Your Ref: 100642352-001
Our Ref: 23/02507/FULL

Date 8th September 2023

Application No: 23/02507/FULL
Proposal: Erection of two storey extensions to rear and side of dwellinghouse and replacement roof and formation of new openings
Address: 1 Main Street Low Valleyfield Dunfermline Fife KY12 8TF

1 Existing Cottage First Floor Plan
A10.3 1:100 @ A1

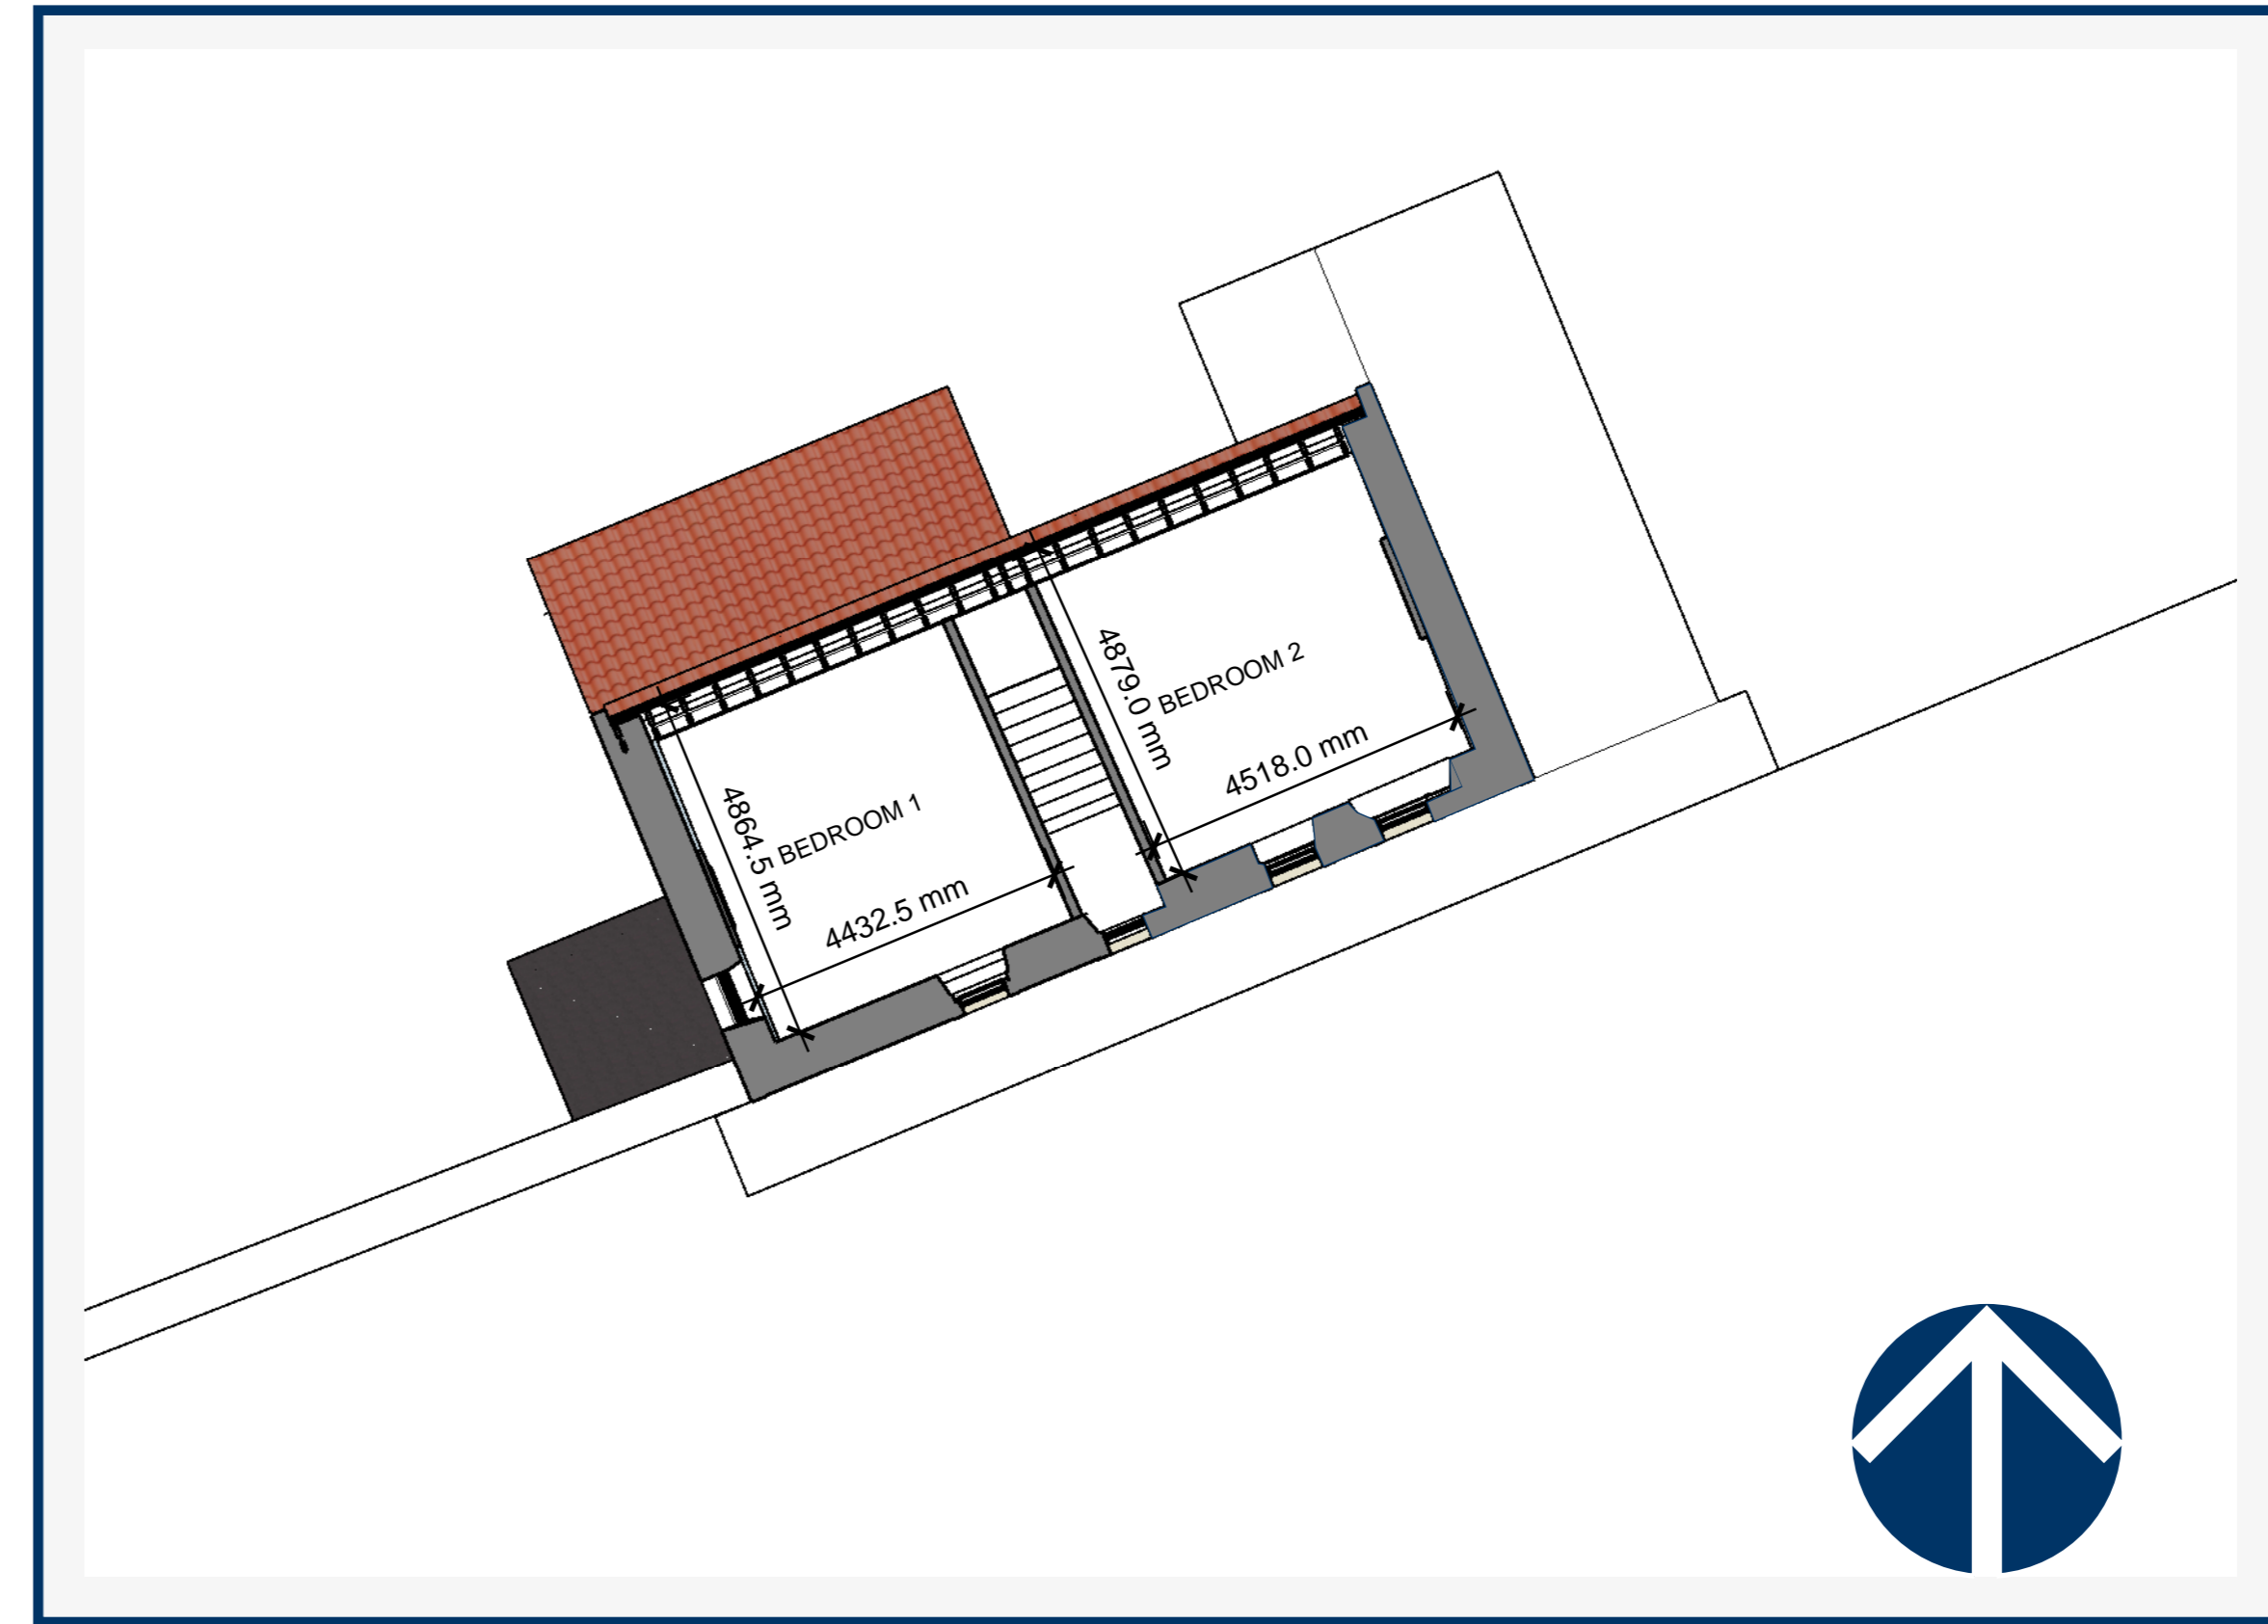
3. Please submit an existing first floor plan at a scale of 1:100.
4. You have not submitted existing and proposed window elevations at a scale of 1:20. If applicable please submit existing and proposed astragal details at a scale of 1:1.

A10.2

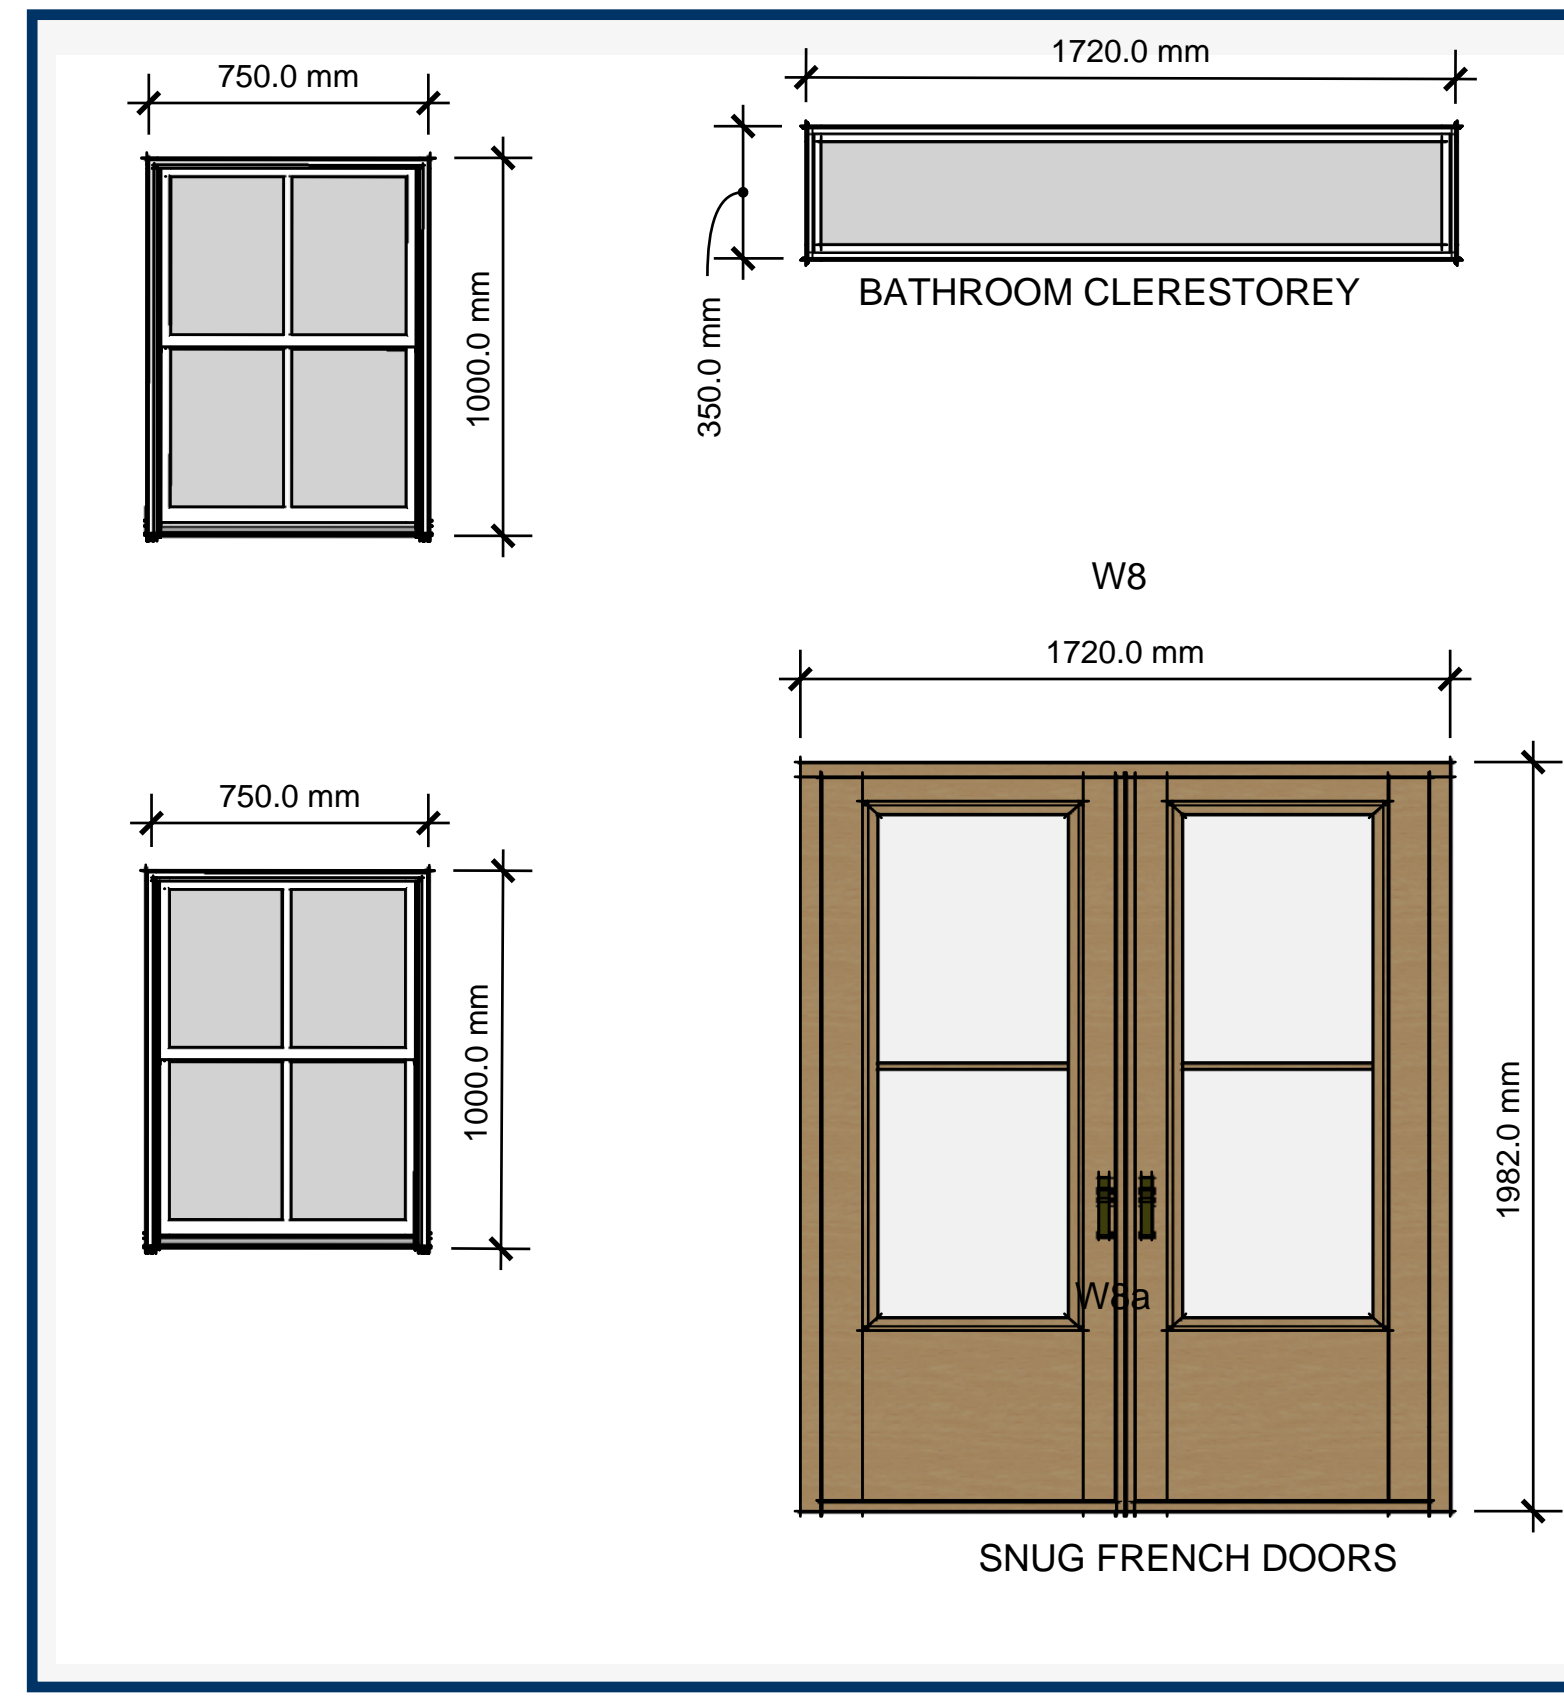
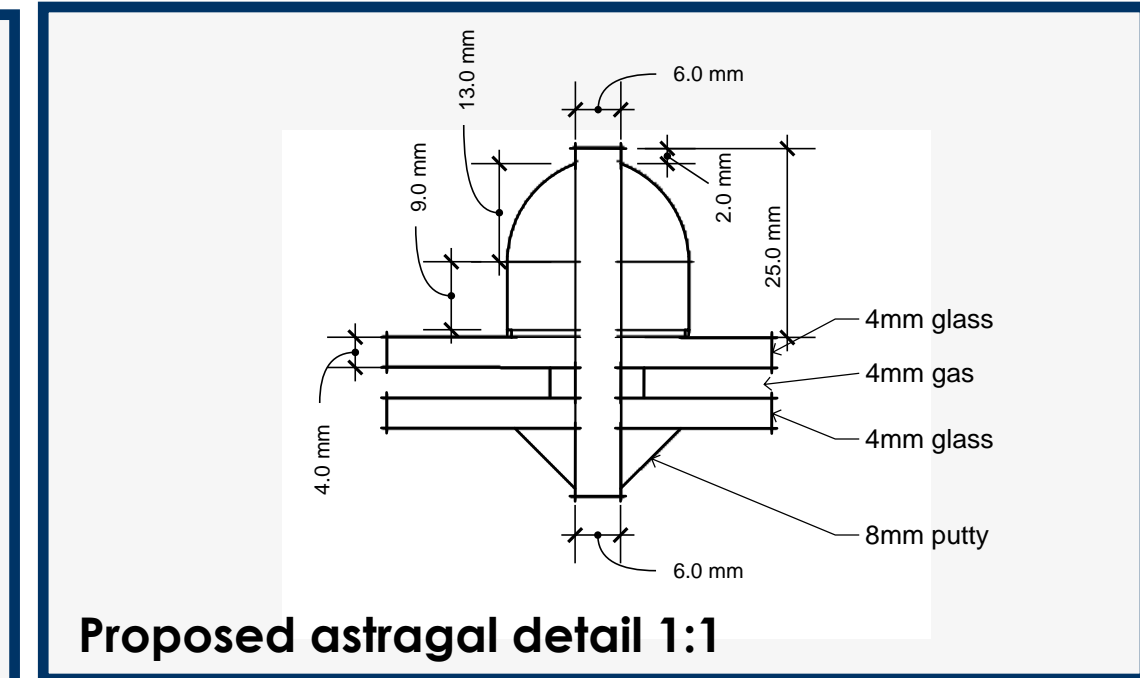
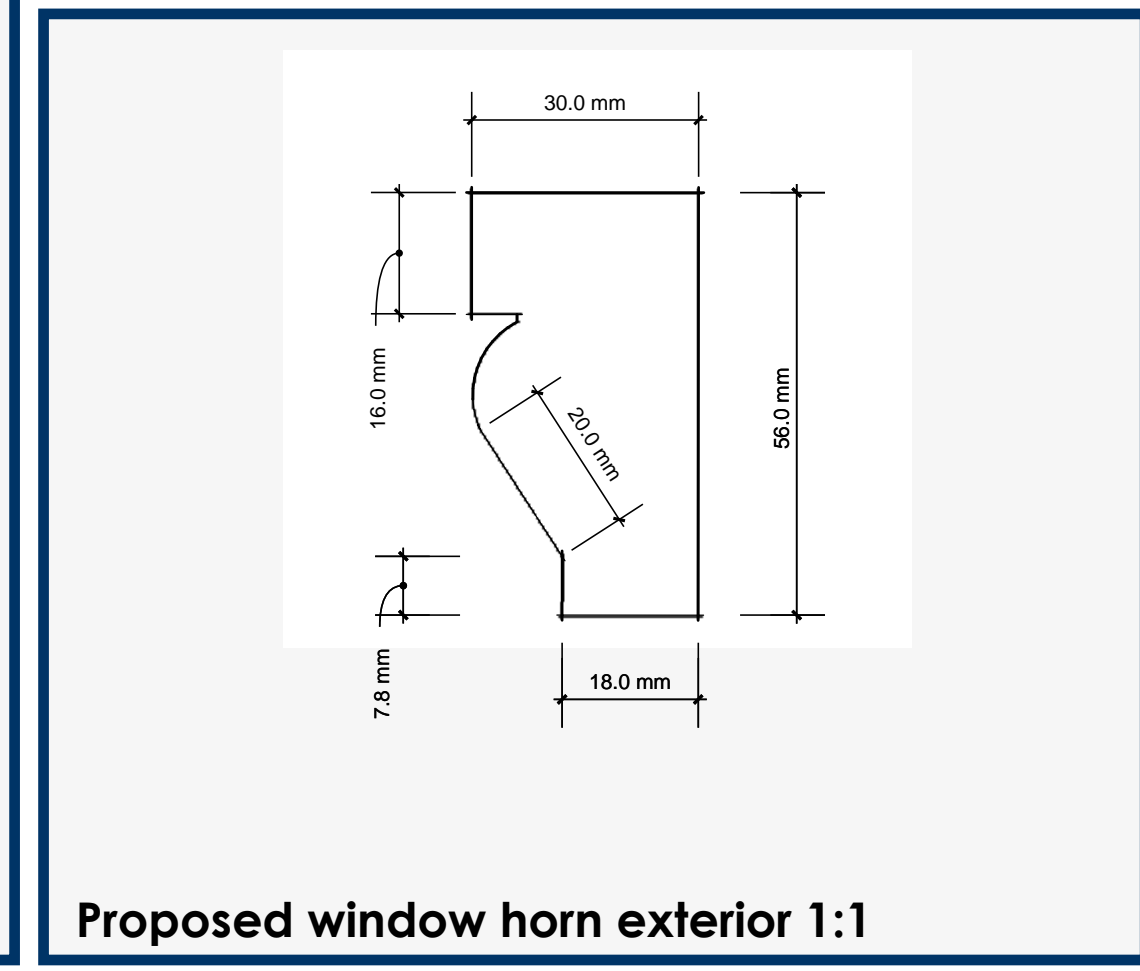
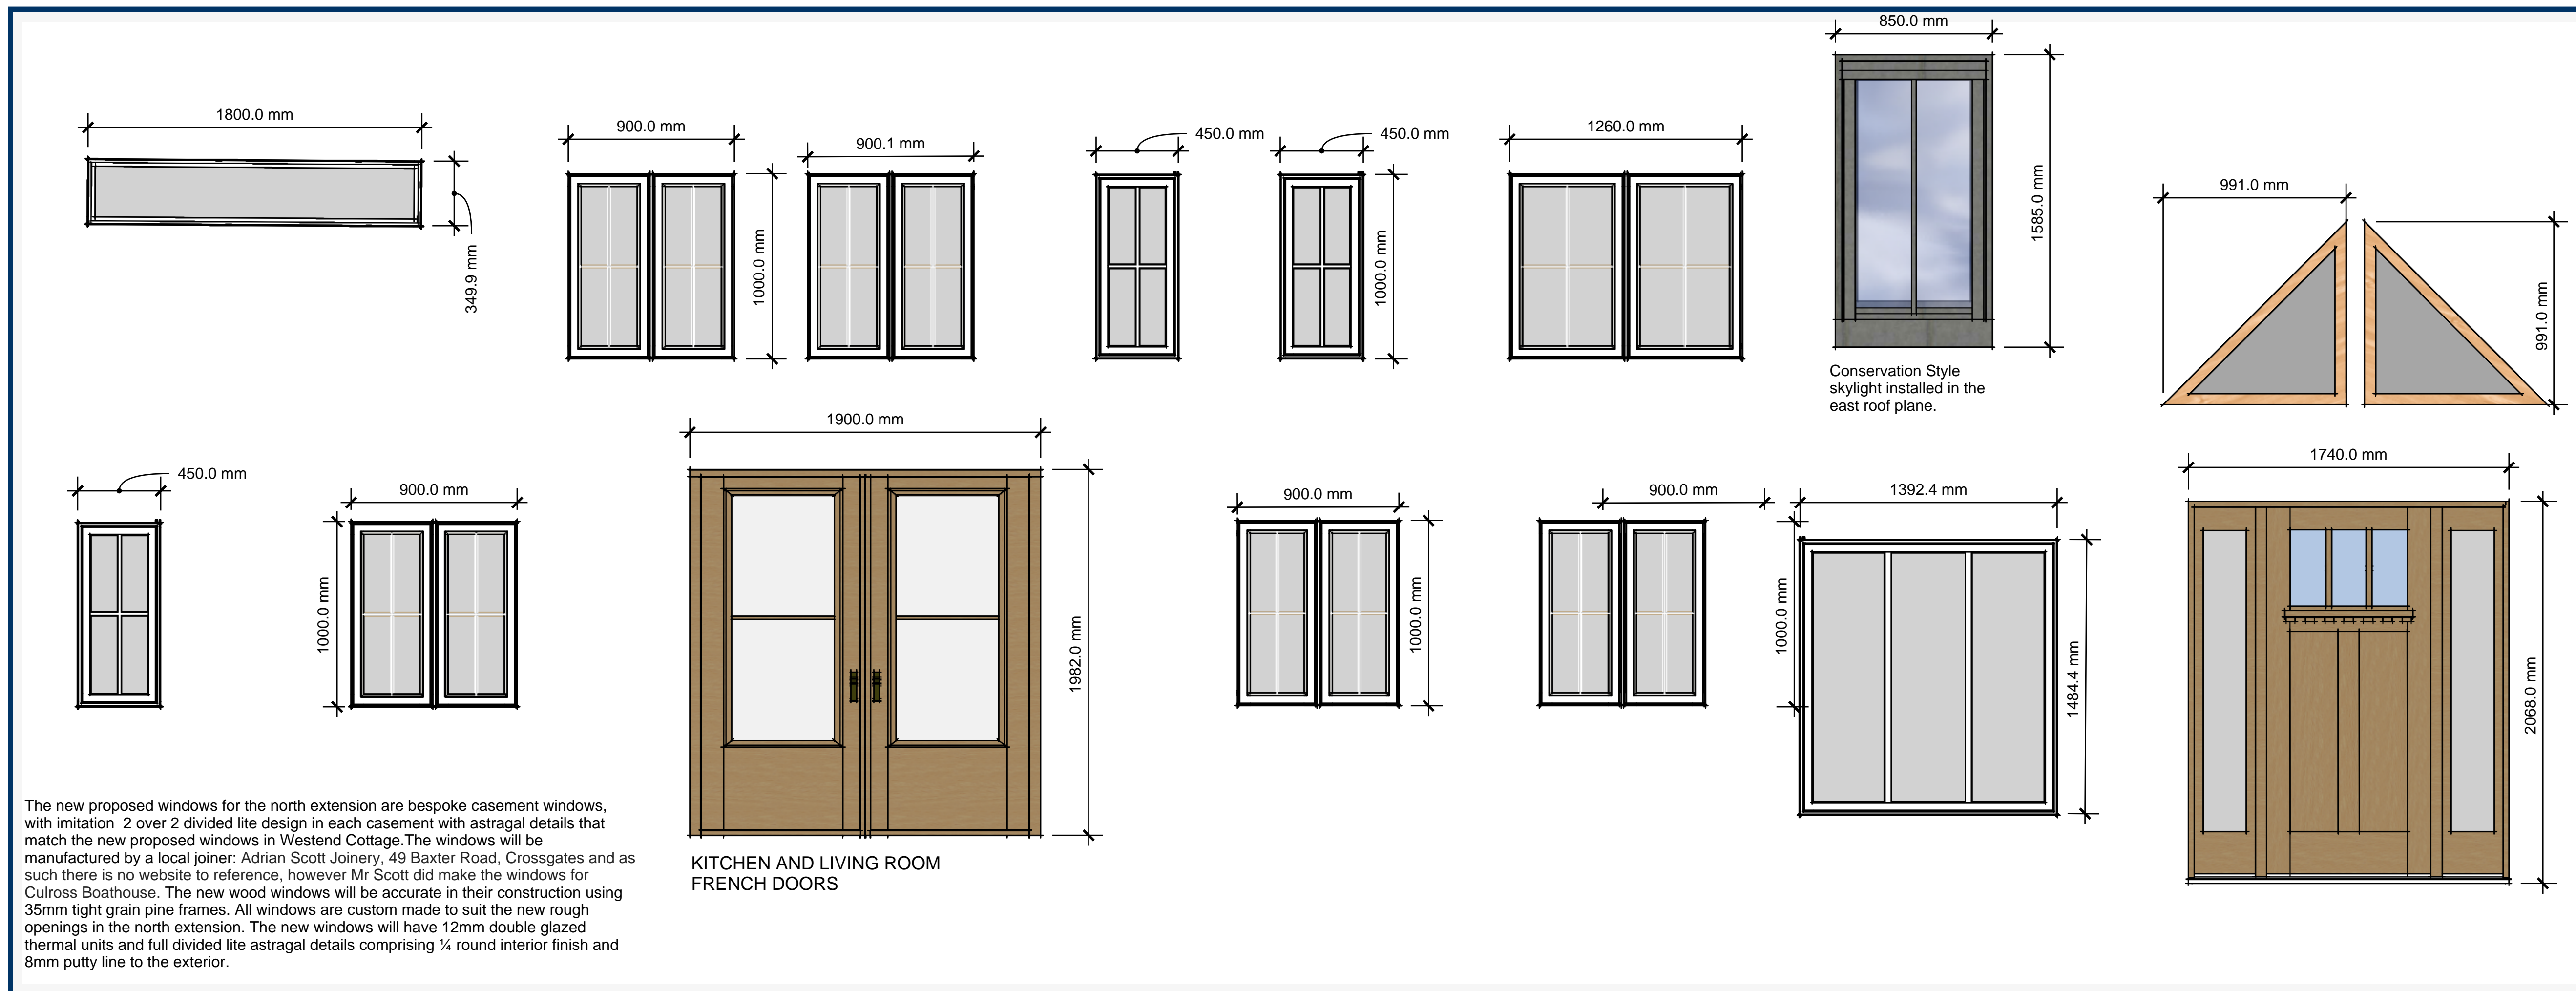
5. You have not submitted proposed door elevations at a scale of 1:20. If applicable please submit proposed astragal details at a scale of 1:1.
